13 February 2017

RESPONSE TO SUBMISSIONS FOR WALSH BAY ARTS AND CULTURAL PRECINCT - R/2017/17/B (SSD 8671)

Michael Soo
Area Planning Manager

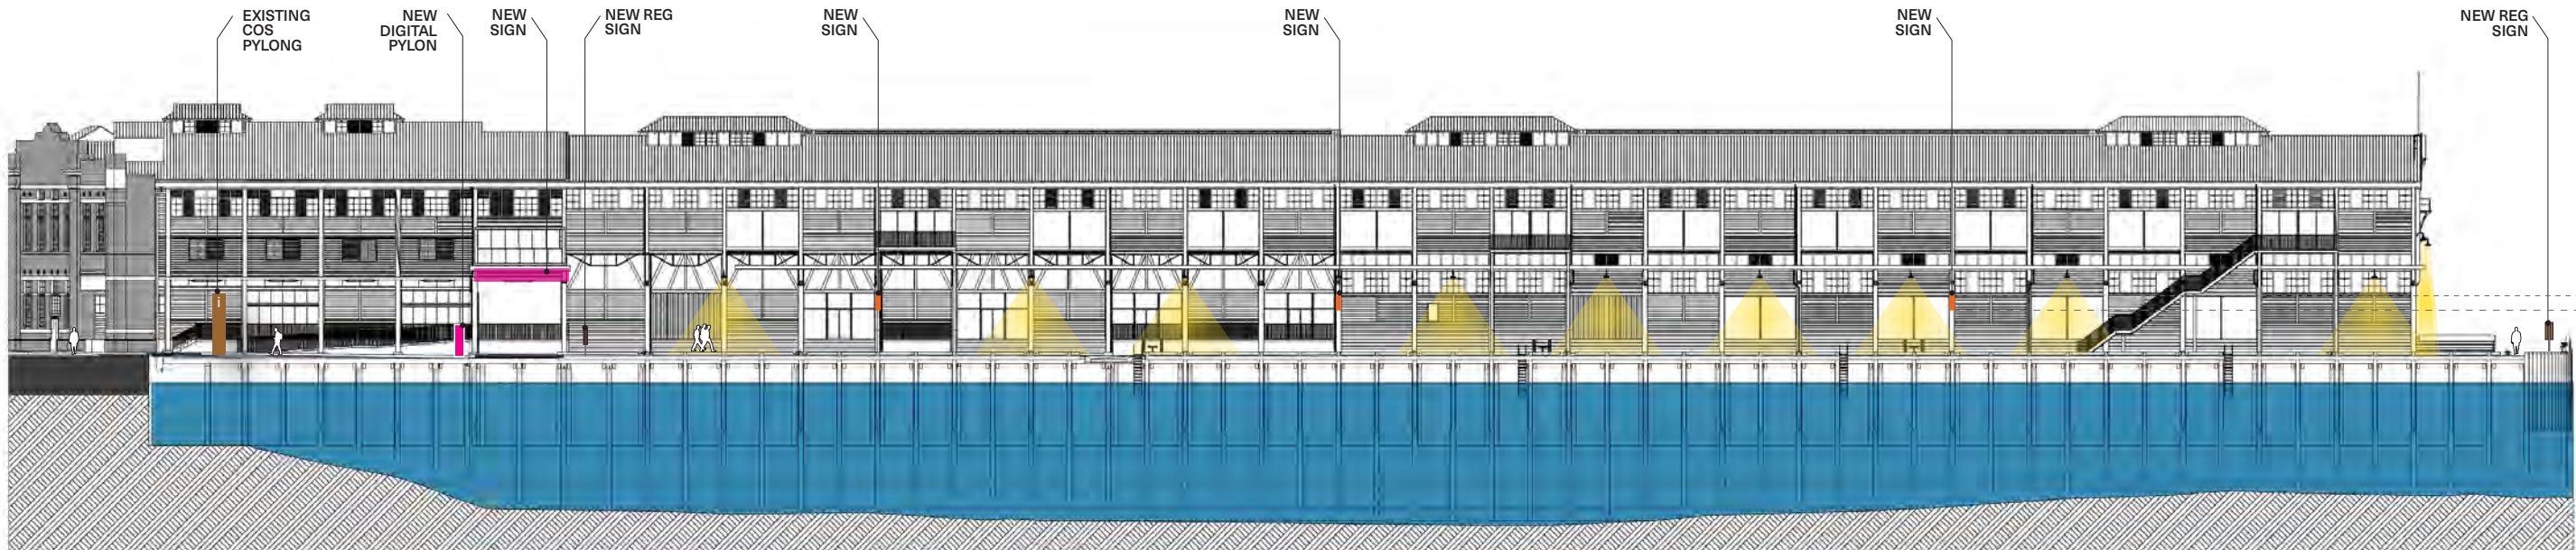
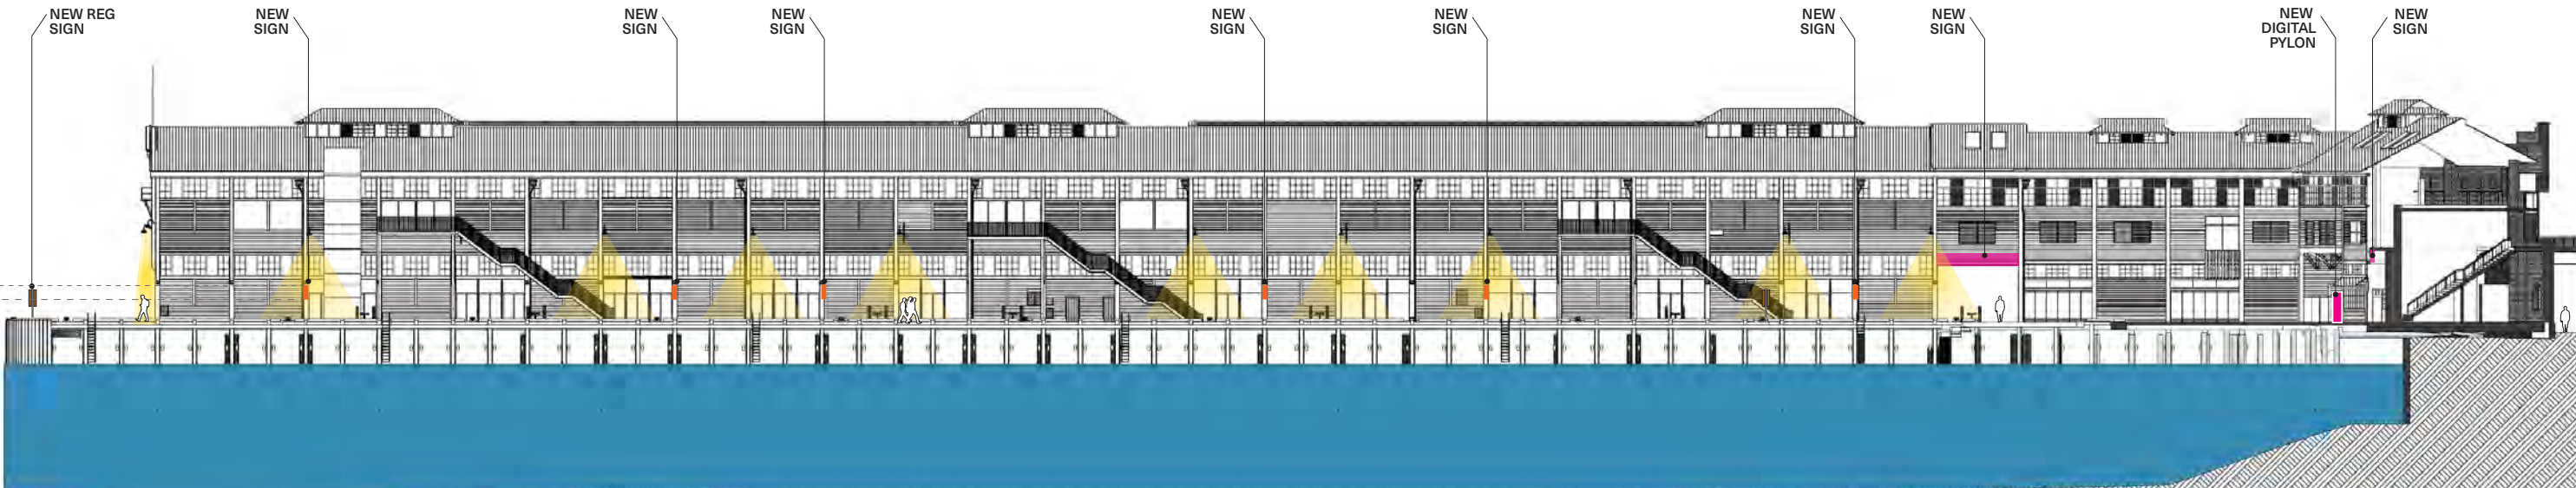
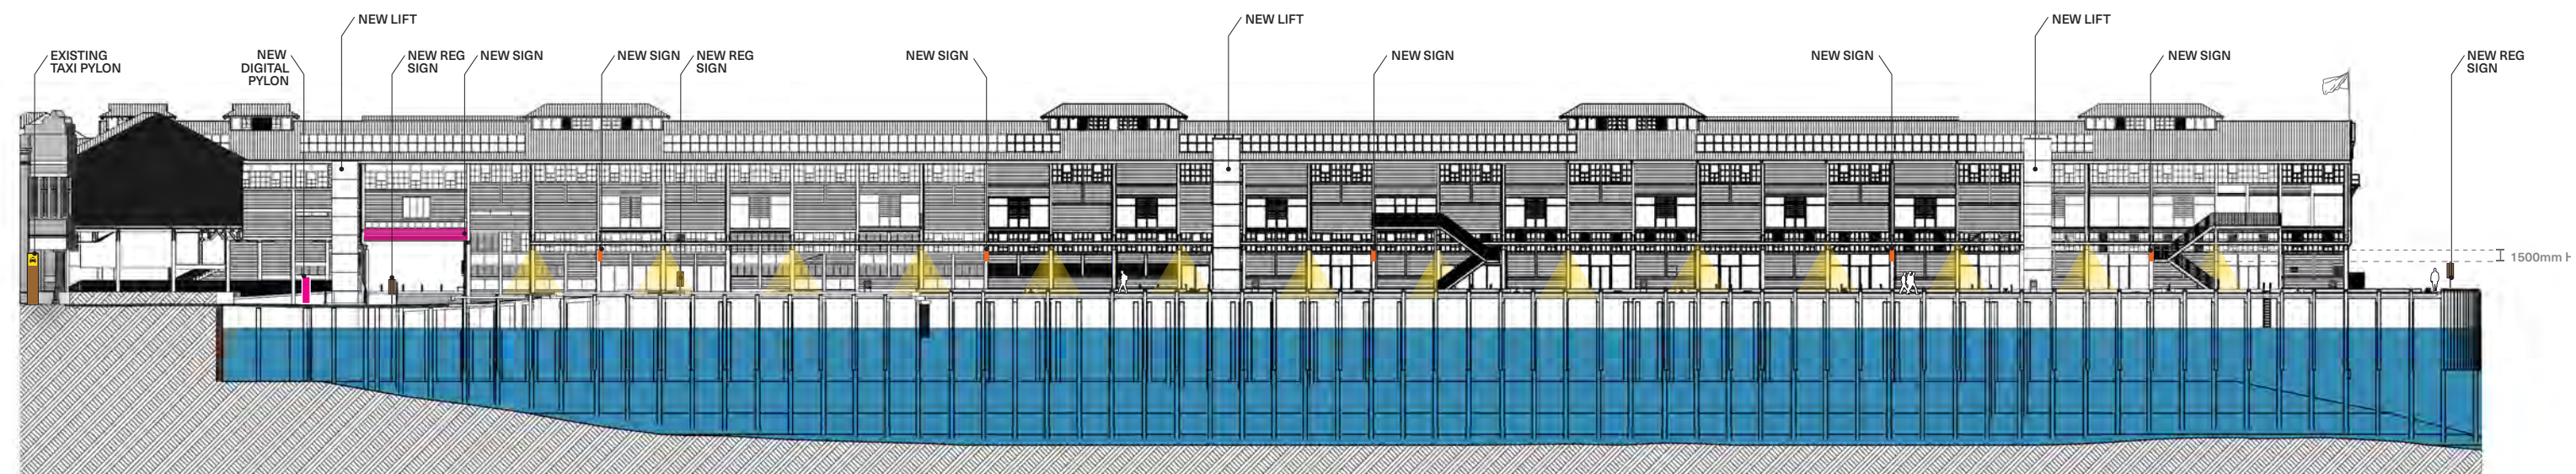
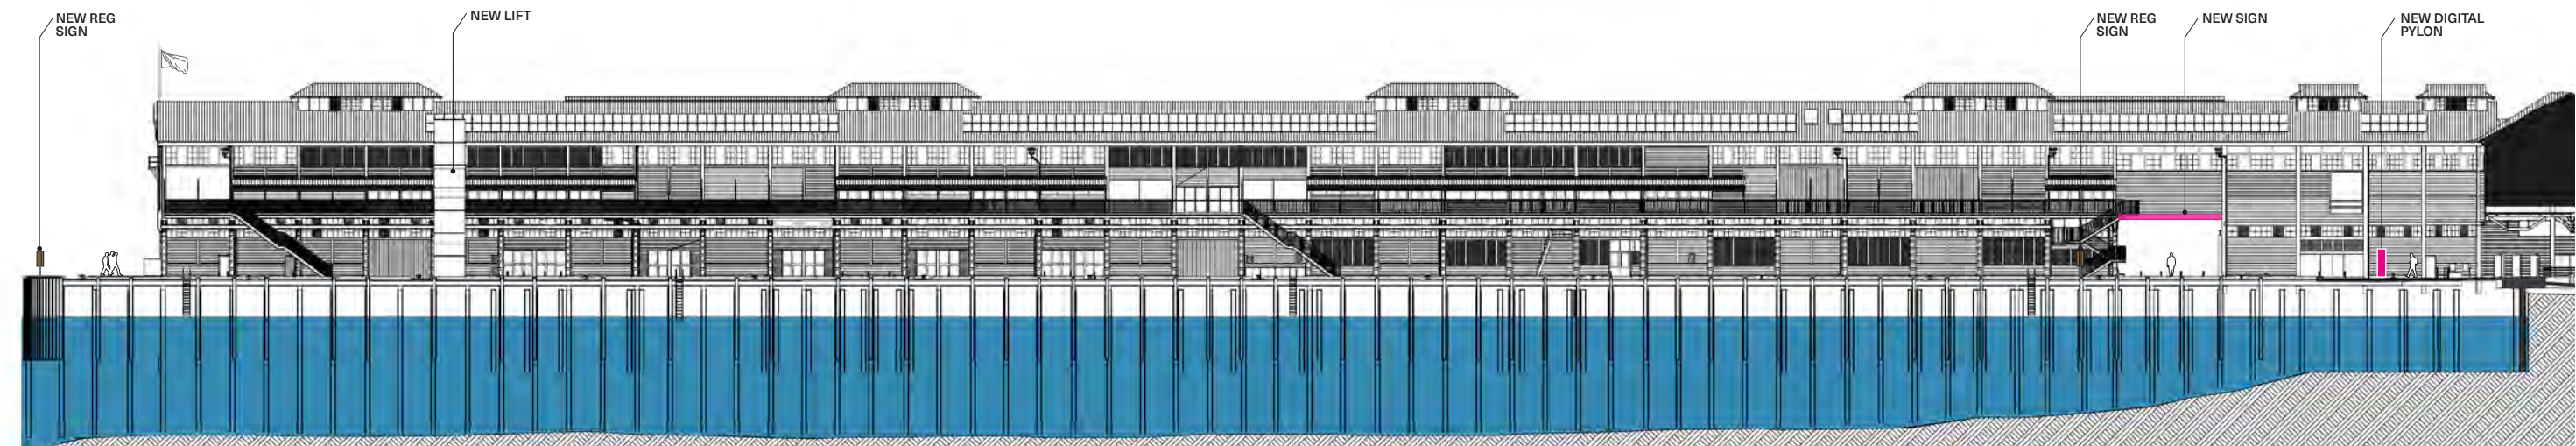
The reduced number of tenant identification signs is supported. While the tenant sign dimensions are shown on the external signage plan key, concerns are raised that it is not sufficiently clear where exactly the signage will be positioned on the building. In particular, where consistent signage types are to be repeated, it needs to be made clear what the clearance to the underside of the sign will be, distance between each of the signs and where on the building facade it will be fixed to. The images shown on pages 11 and 12 of the relevant RTS document are not scaled. A signage strategy, including any 'concept strategy' should contain this level of detail to ensure consistency and that there is an appropriate relationship between the signage and the building, particularly given its heritage significance. It is the City's preference that this level of detail is clarified now and not part of future consultation.

It is noted that no dimensions for the digital wall signs have been provided. Again, the images submitted are not scaled and the key does not clarify the dimensions of those particular signs. At a minimum, a signage strategy, even at 'concept' stage should include dimensions of all signs.
